Your Ref: OWPC20738
Our Ref: EP/166/18/HH 13-11-2018
Please ask for:
Zac Denton

Erection of a two storey rear extension, second storey enlargement of side dormer and conversion of garage to study including demolition of existing conservatory
100 Sea Road East Preston

Thank you for your internet representation made on 28th November 2018 which has been recorded as '**an objection**' with the comments as follows:

PROPOSED FLOOR PLANS 1:50

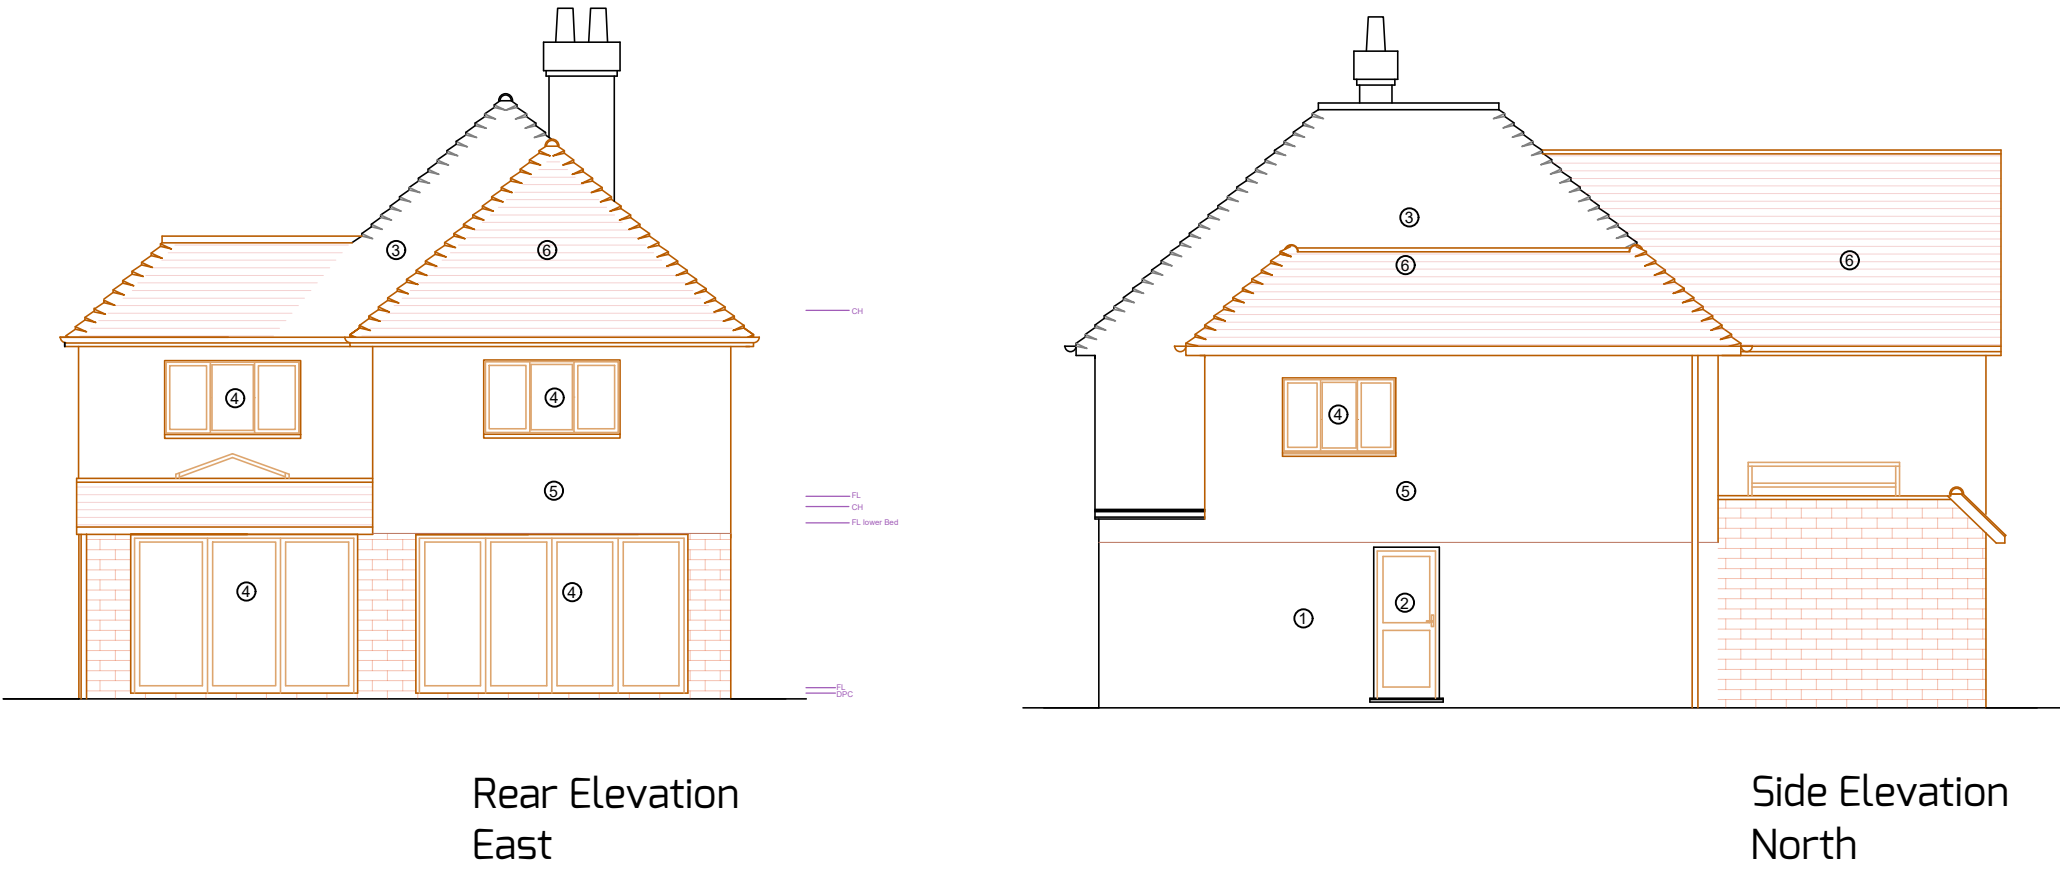
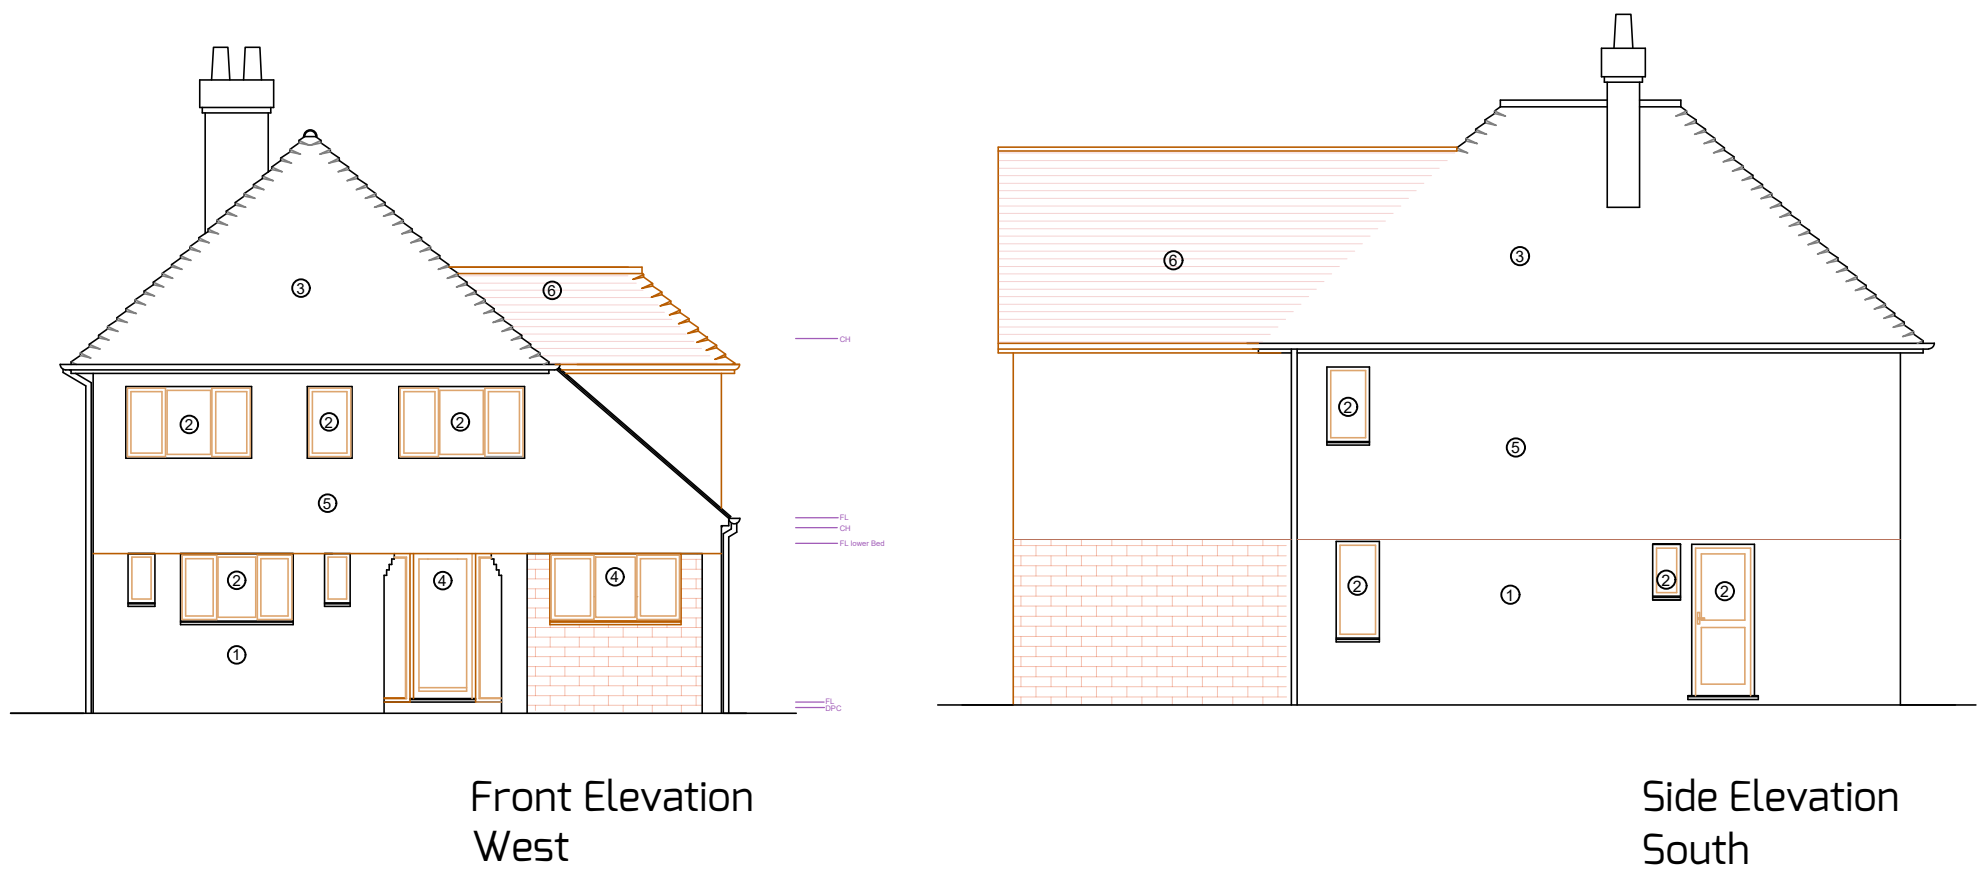
We feel that a double storey extension would be totally overbearing for the small gardens at this end of Sea Road which overlook the bungalows of Normandy Lane.

We use our conservatory as a dining room and our double doors open onto a patio area directly opposite what will be the huge new brick wall of the proposed extension which extends 3.5m beyond the current building line.

A single storey extension would have been fine but the proposed two storey is close to our boundary and also has a full height apex roof. It will totally overshadow and enclose our small patio area and restrict the light, particularly to our small utility room.

We were not aware of our neighbour's plans until after planning permission had been submitted but we are sure that the plans could be revised to create the extra living space needed without the enlargement of bedroom one and we hope a compromise will be considered to avoid this double storey section.

We feel the current proposal would make this house out of scale with other houses in Sea Road. The garden is too small for this size of extension which will be overpowering in ground space but more concerning is the height impact that both the second storey enlargement of the side dormer and a two storey extension will create.

It is not just about loss of privacy and light but the visual impact from all sides and when looking directly from Normandy Lane the road behind us. At this end of Sea Road the houses are close together with particularly small gardens backing onto bungalows and if this is allowed to happen it will set a precedent for other two storey extensions in Sea Road which will only see the area becoming even more built up.
